Newcastle Jockey Club Stable Development (SSD-12982045)
Request for Further Information

ATTACHMENT A – REQUEST FOR INFORMATION

FULL SIZE ON ORIGINAL 0 1 2 3 4 5 6 7 8 9 10 11 12 13 14 15 cm

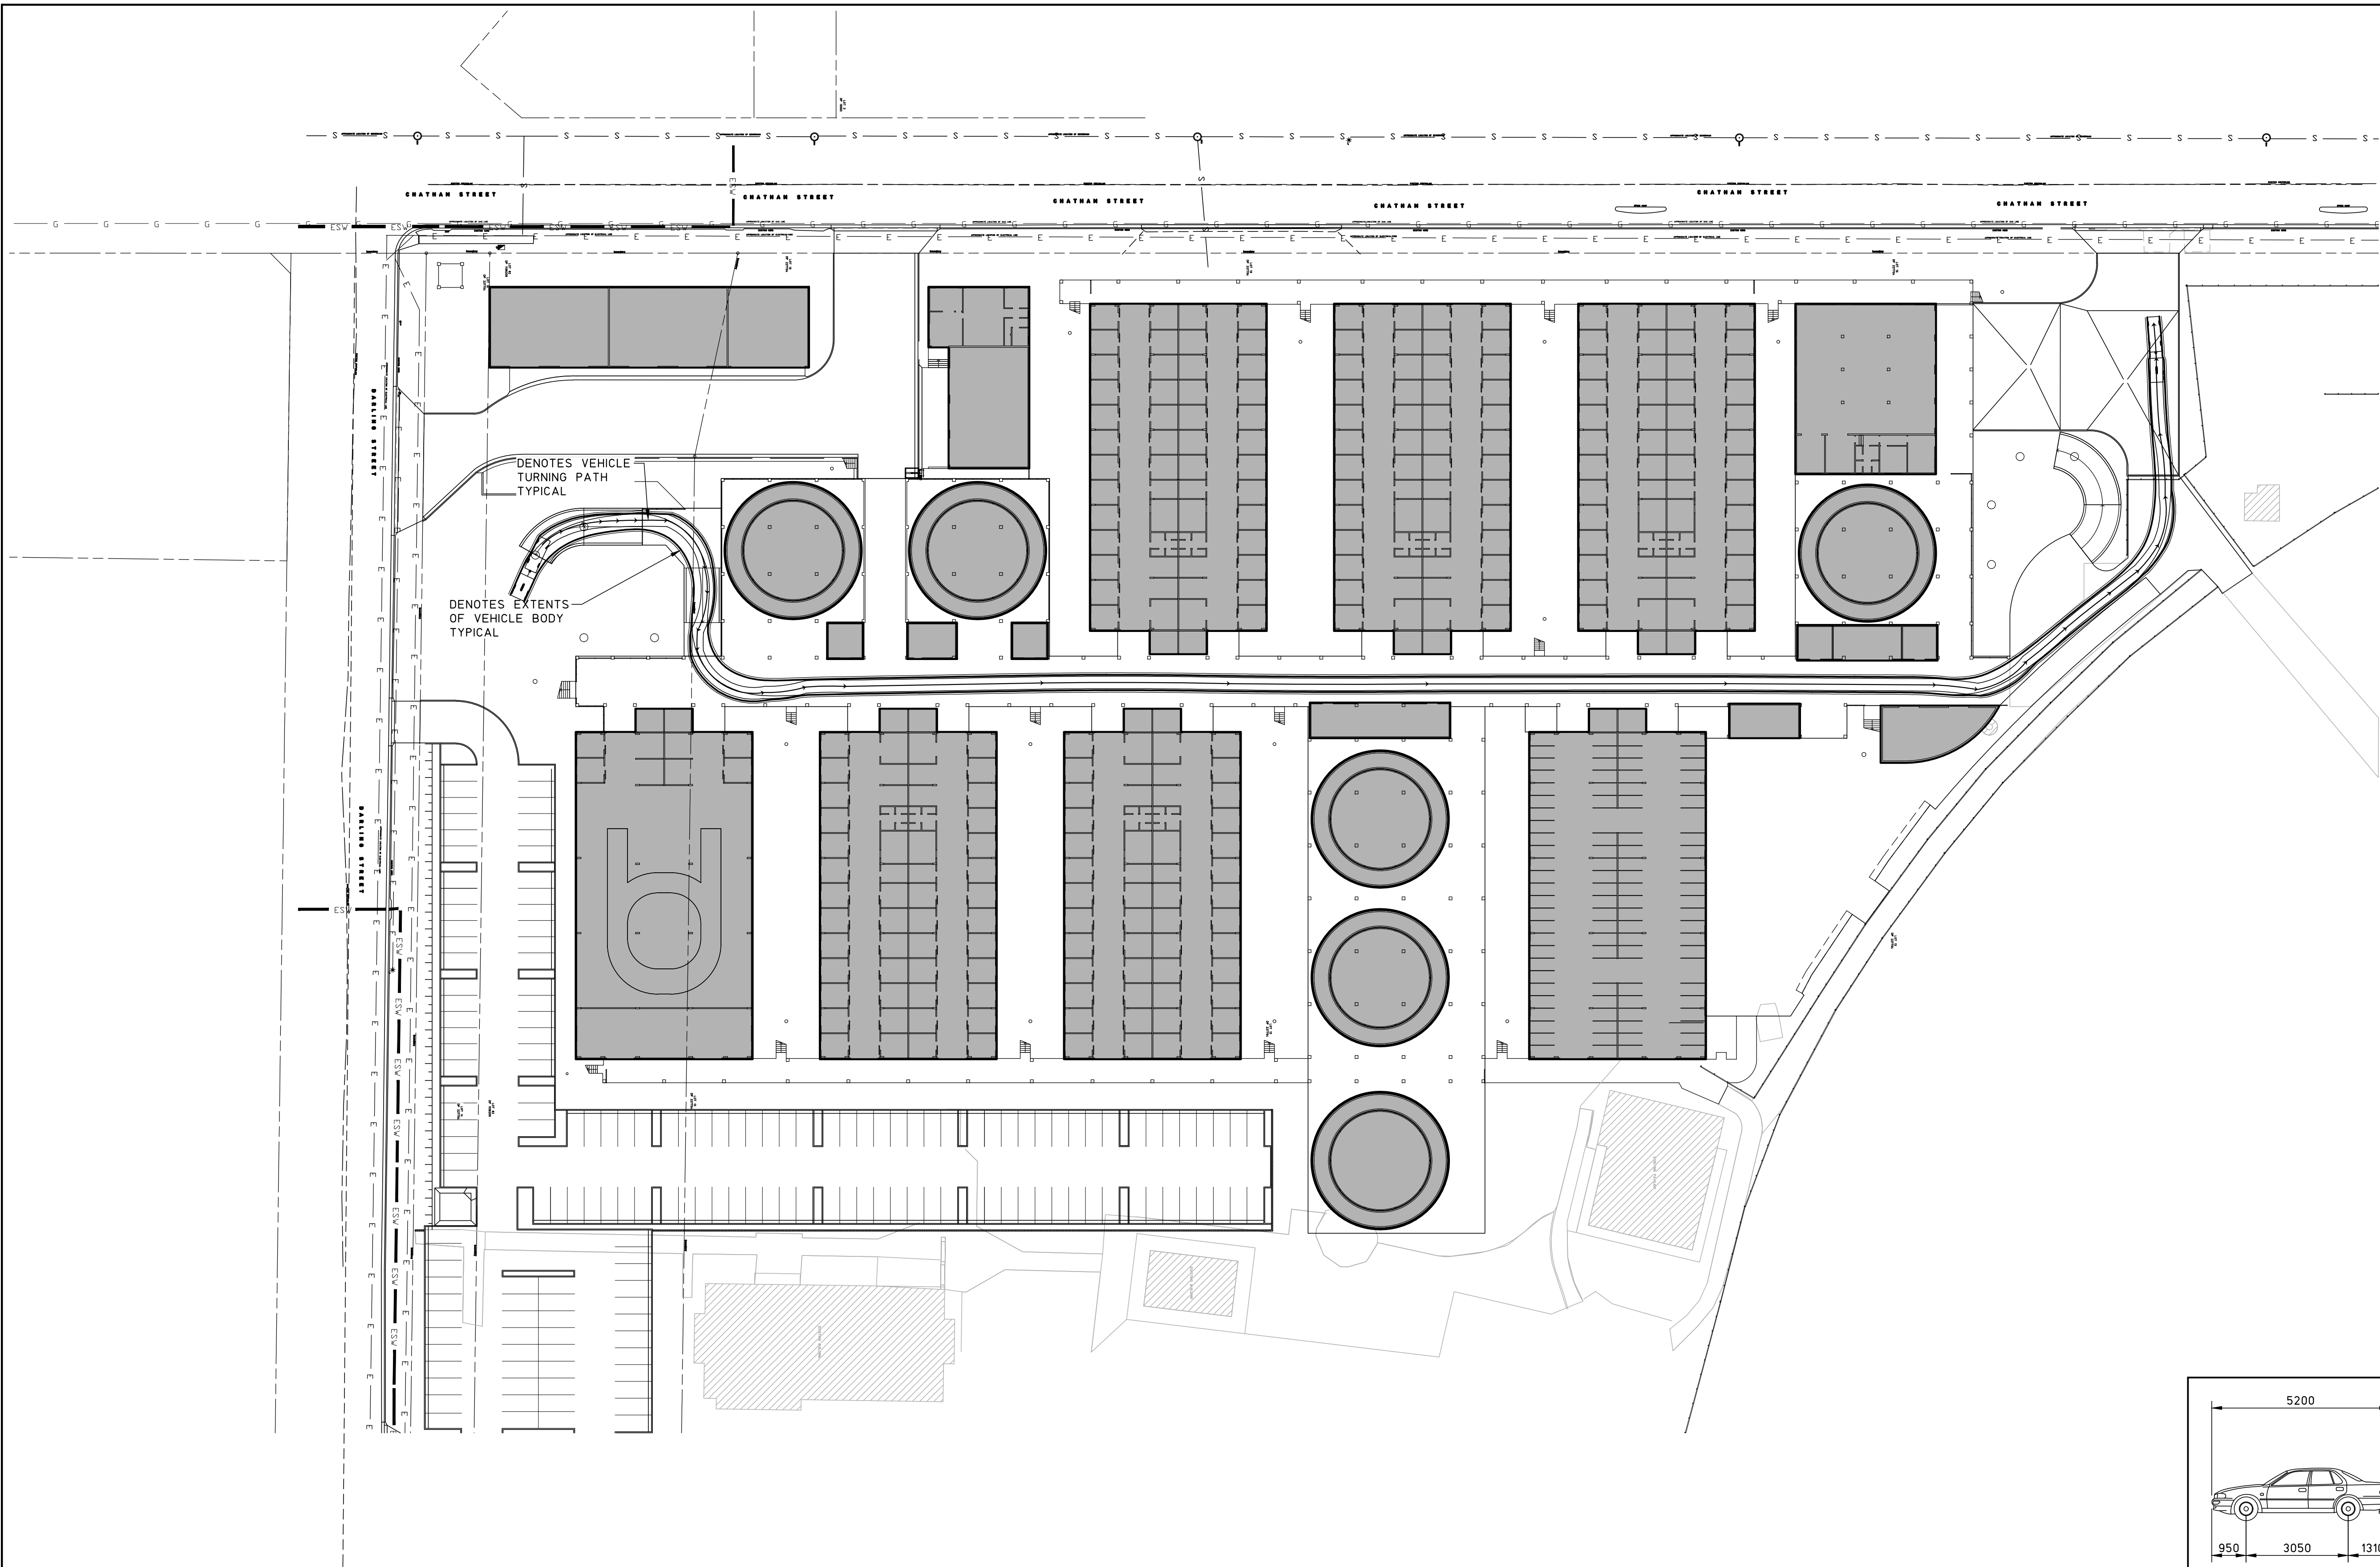
The Department requests that consideration be given to the submitted turning paths and the concerns raised by Council on their usability and potential safety issues. The Department requests that the vehicle movements on the upper and lower concourses be quantified to ascertain the potential conflicts with traffic in the Equine and Goods Drop Off Loading Zone.

## Appendix 2 – Heavy Vehicle Detour Map

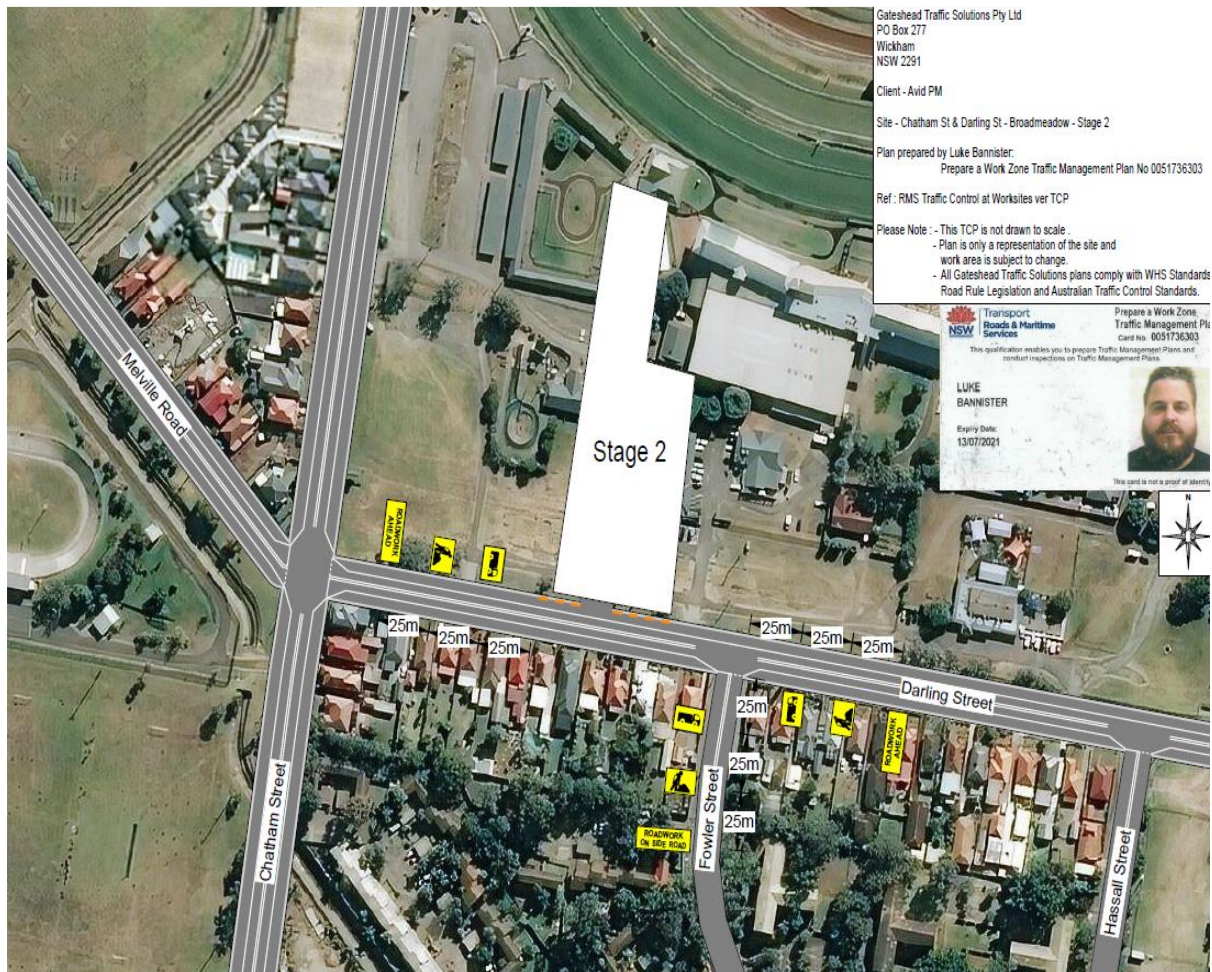
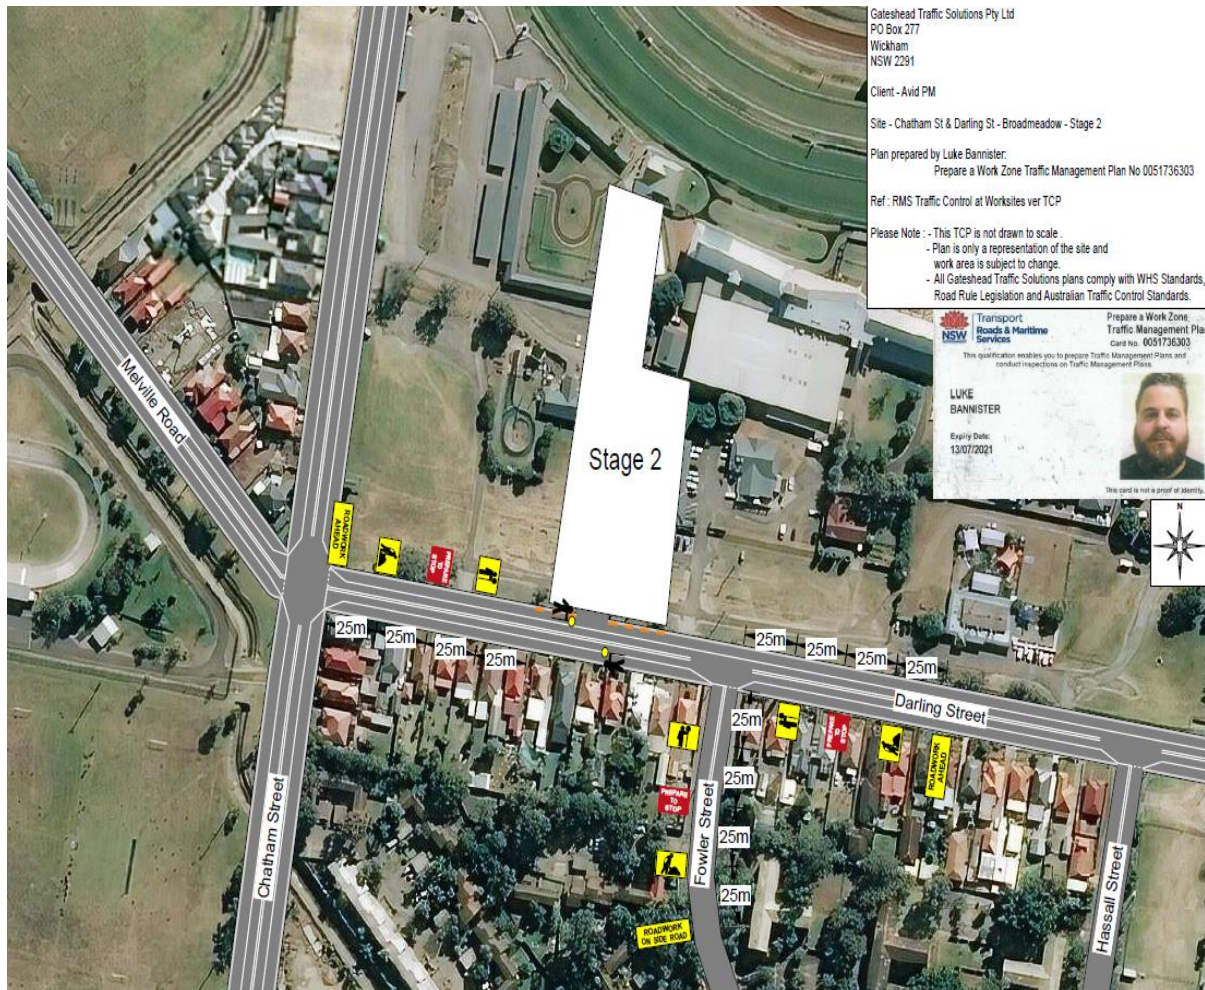
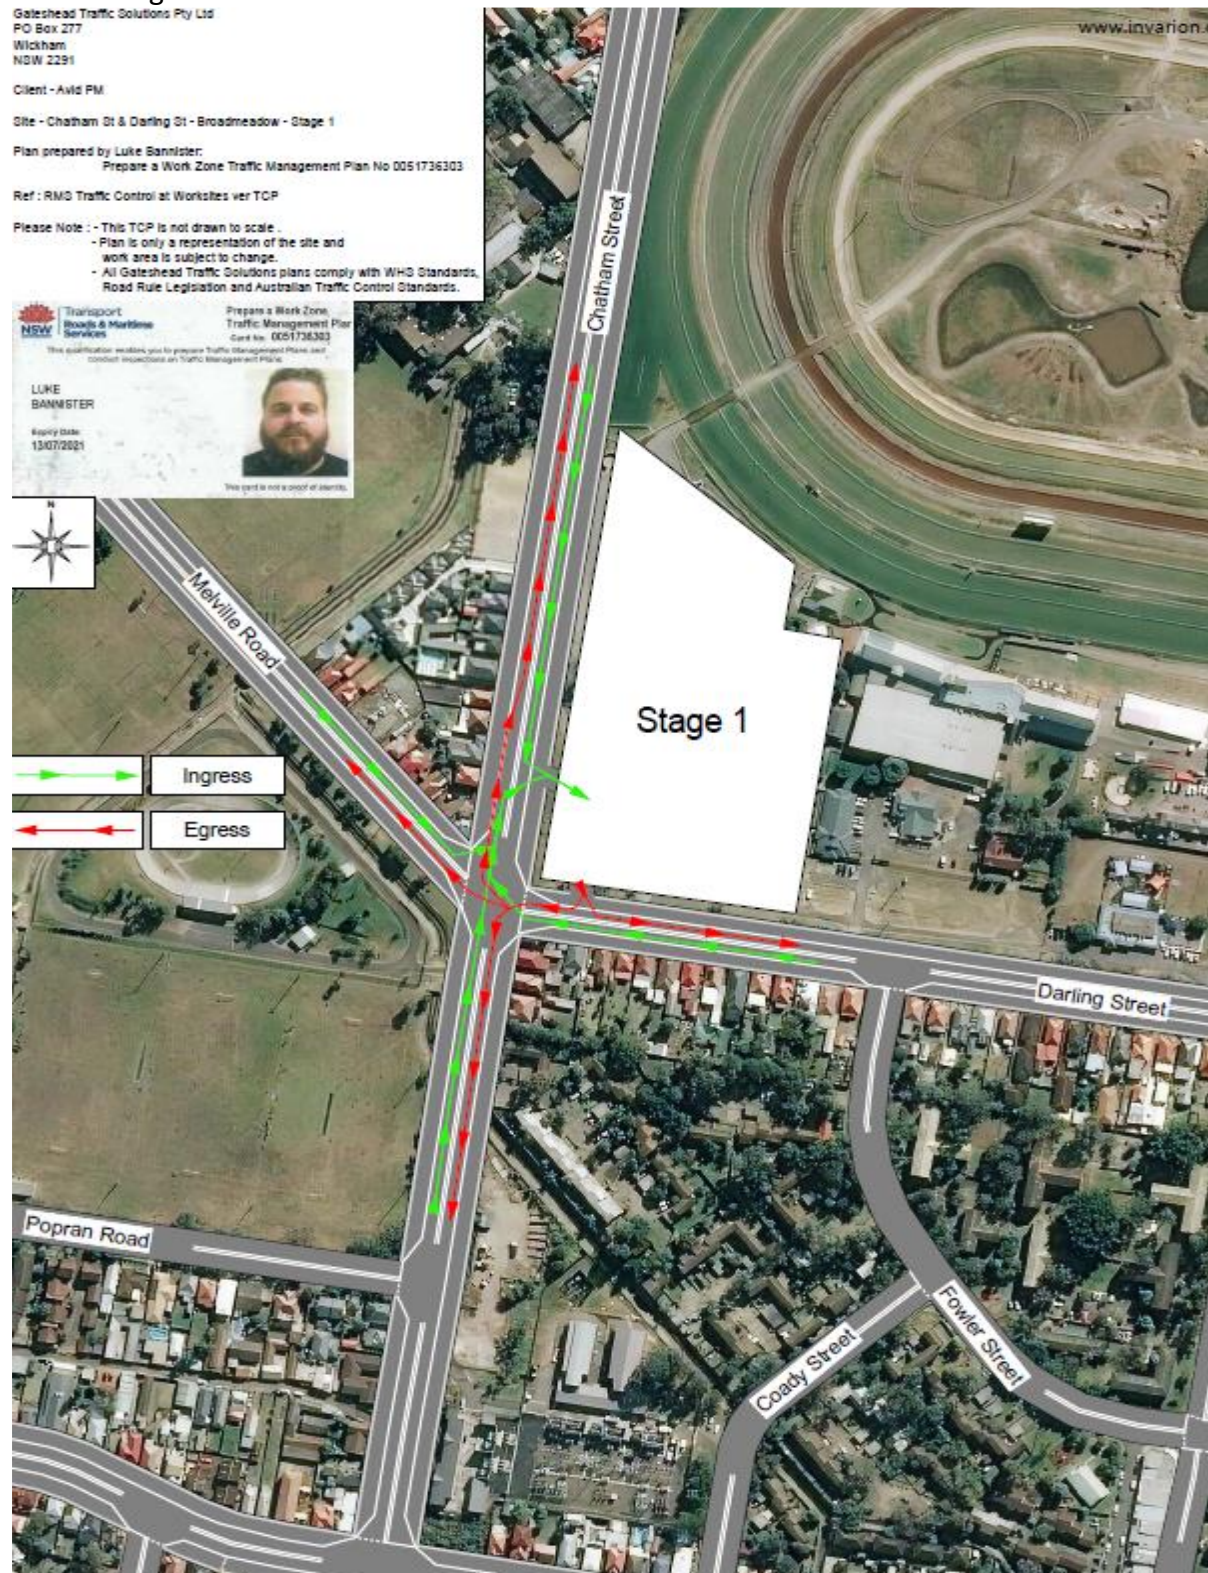
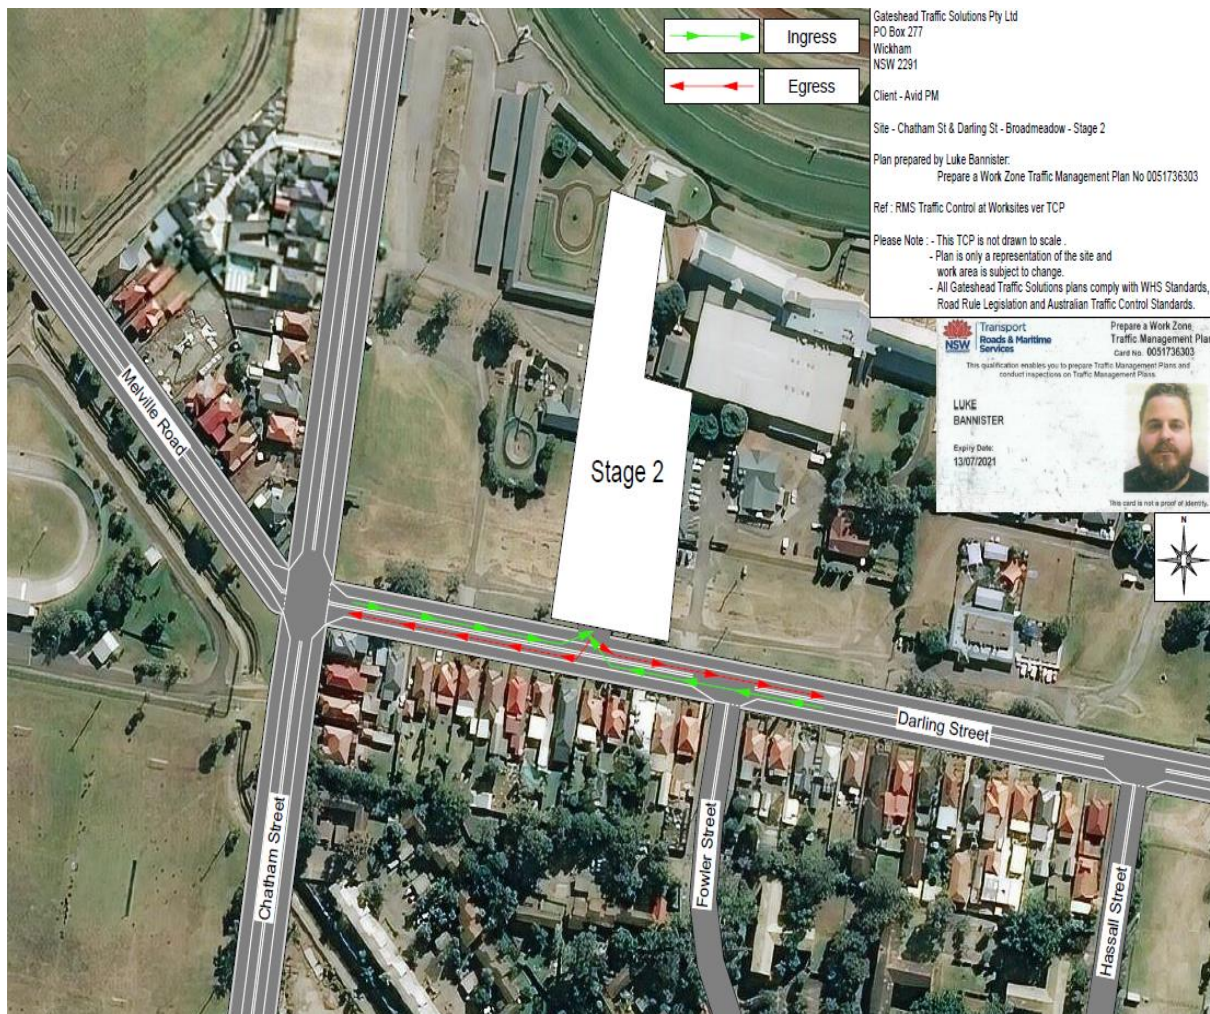
The CTMP makes reference to parking be available on site for construction vehicles. The Department requests confirmation whether this includes construction staff vehicles? In addition, does this location changed between the stages of construction?

The CTMP has provided heavy vehicle routes for the local road network. The department requests these routes be extended to demonstrate the paths that vehicles will take to the closest collector roads.
